**From:** Sue Howell  
**Sent:** 12 July 2018 16:03  
**To:** Anita Gardner  
**Cc:** Mark Warwick; Tracey Headley-Smith  
**Subject:** A/93/18/DOC

I have taken a look at the DOC application A/93/18/DOC and spoken with both Mark Warwick and Tracey Headley-Smith re this.

My conclusion from the information submitted to date would be that **I would not be able to recommend discharge of condition 23** until further details were submitted.

Drawing title
Site Plan
With additional Trees

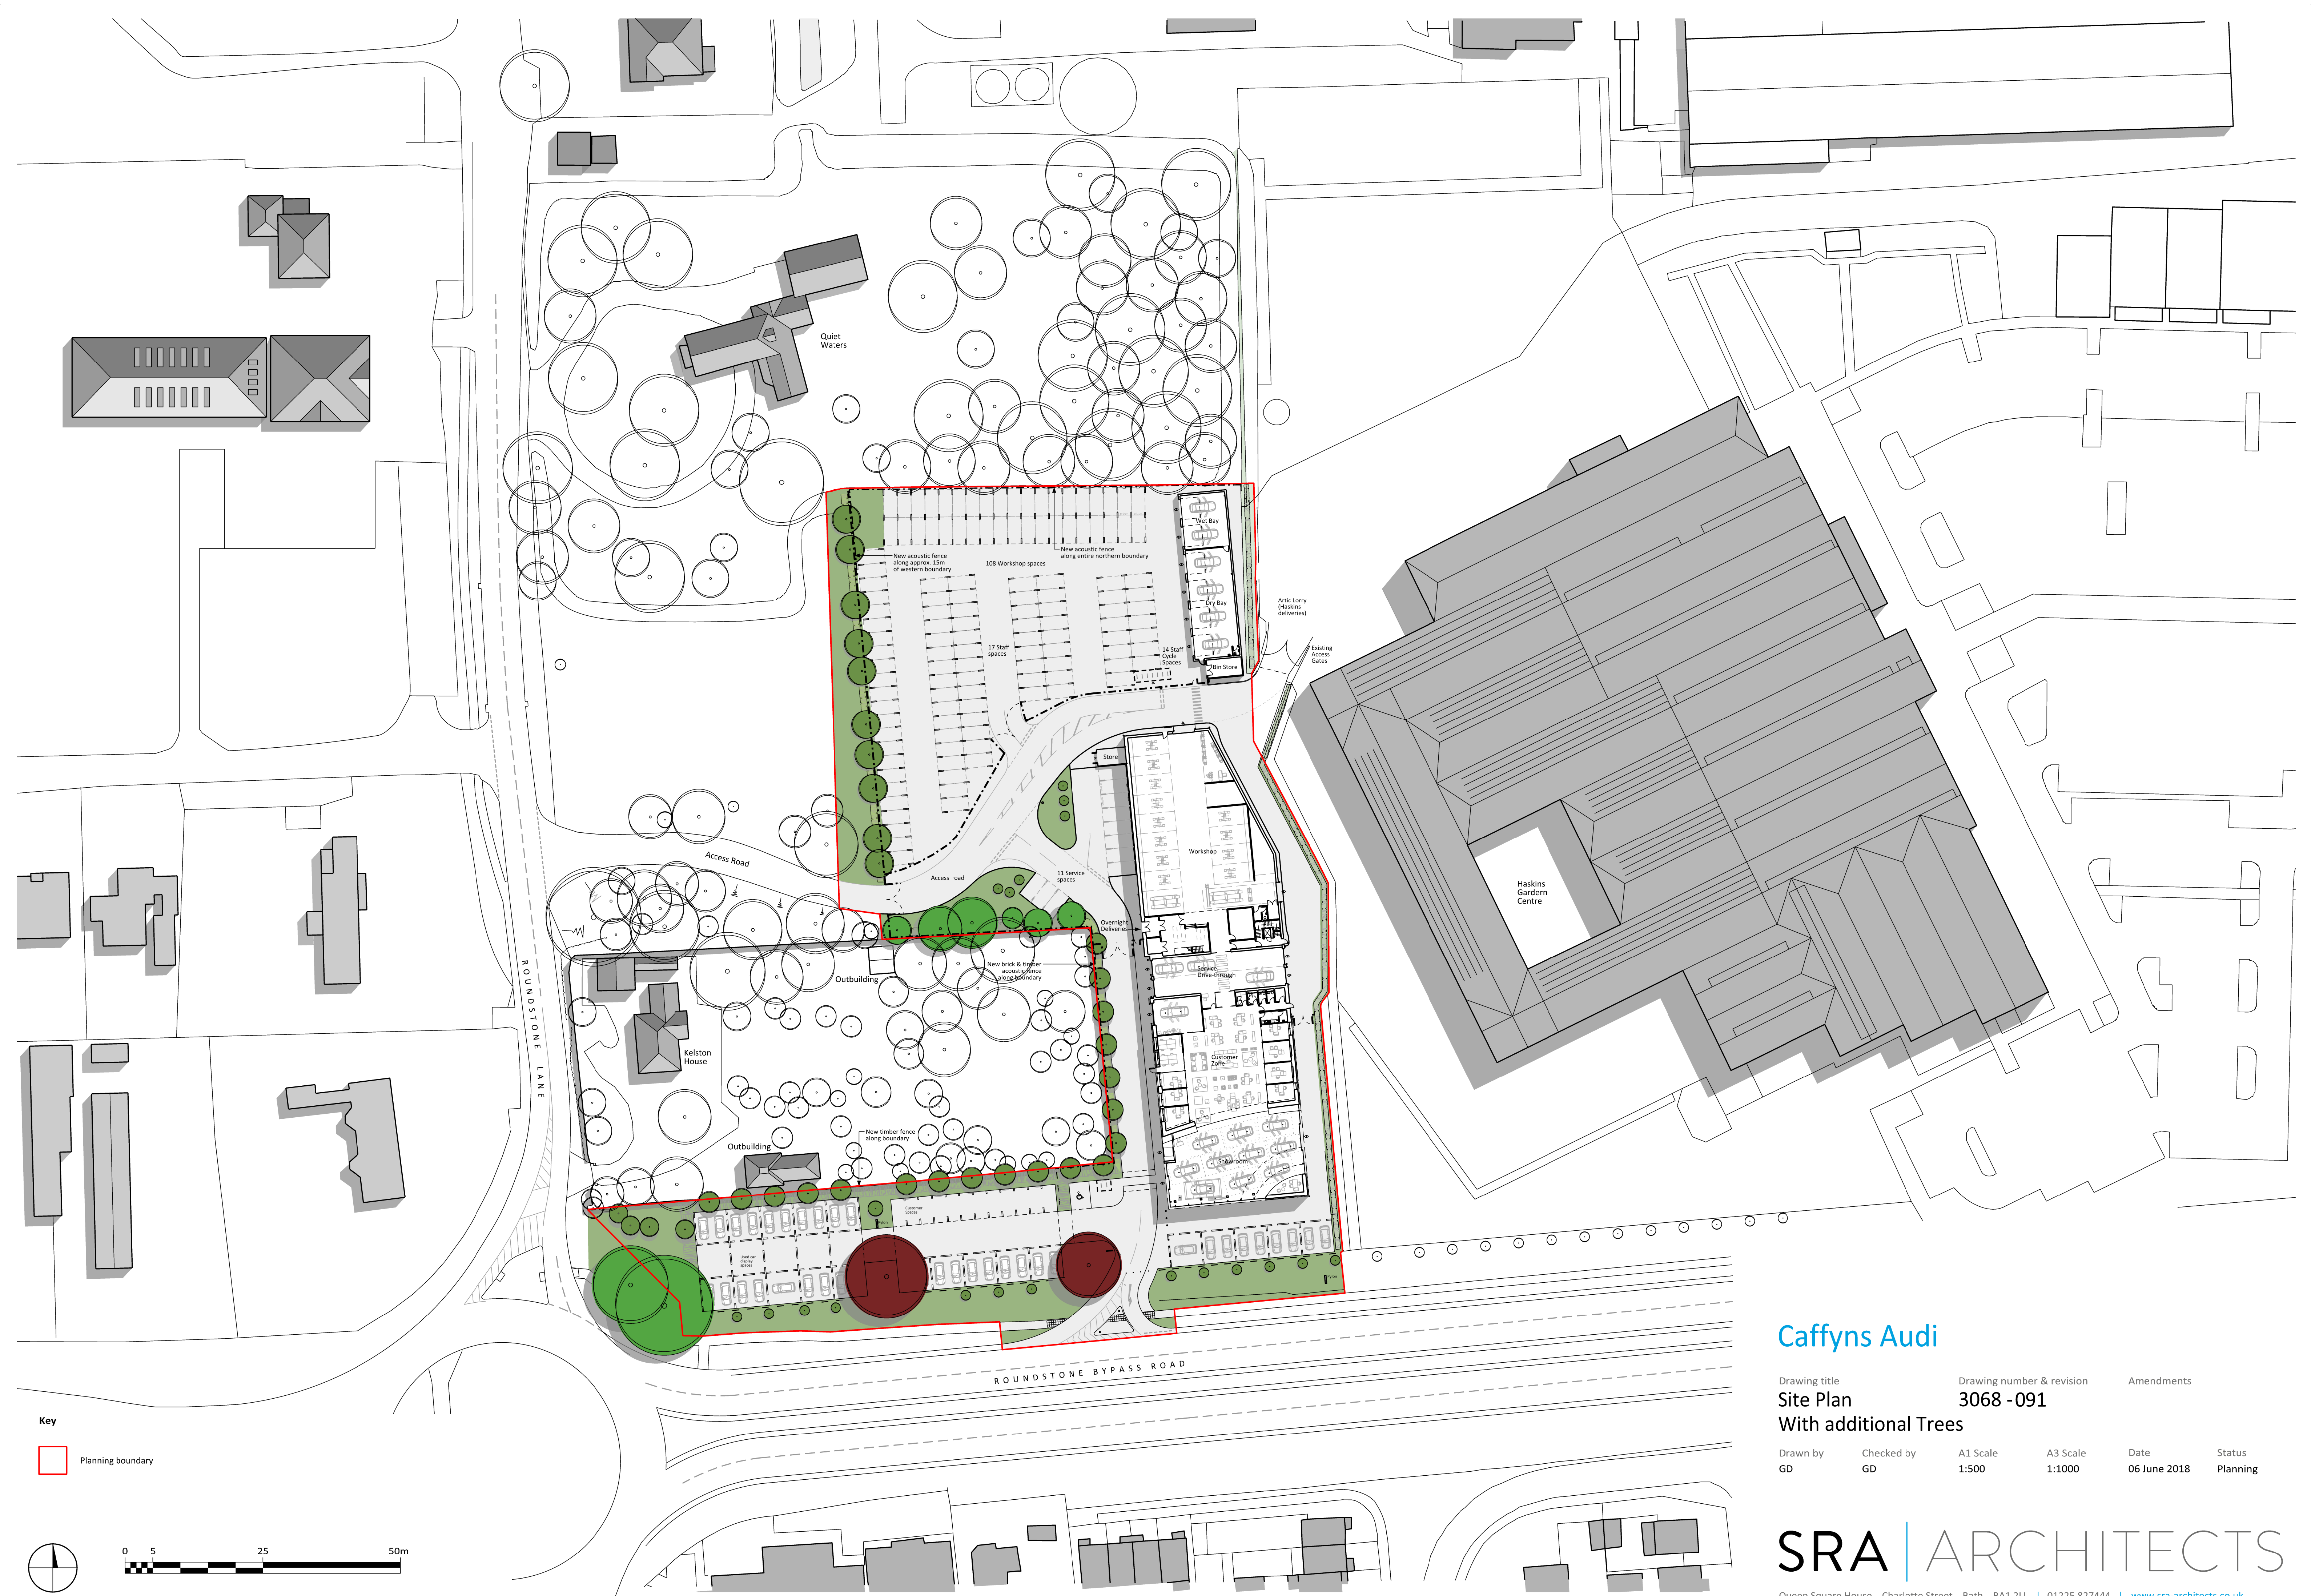
The two drawings that have been submitted under this application include Landscape Strategy Plan 873/LA4 which is indicative and shows no change from that submitted under A/167/17/PL the other drawing Site Plan with additional trees 3068-091, also indicative, needs to detail the trees and shrubs to be included in the whole scheme in plan form detailing species choice, planting density, actual numbers shown in each location and size at time of planting. This would need to also include the additional trees in their locations as agreed on site with Mark and also the existing to be retained trees.
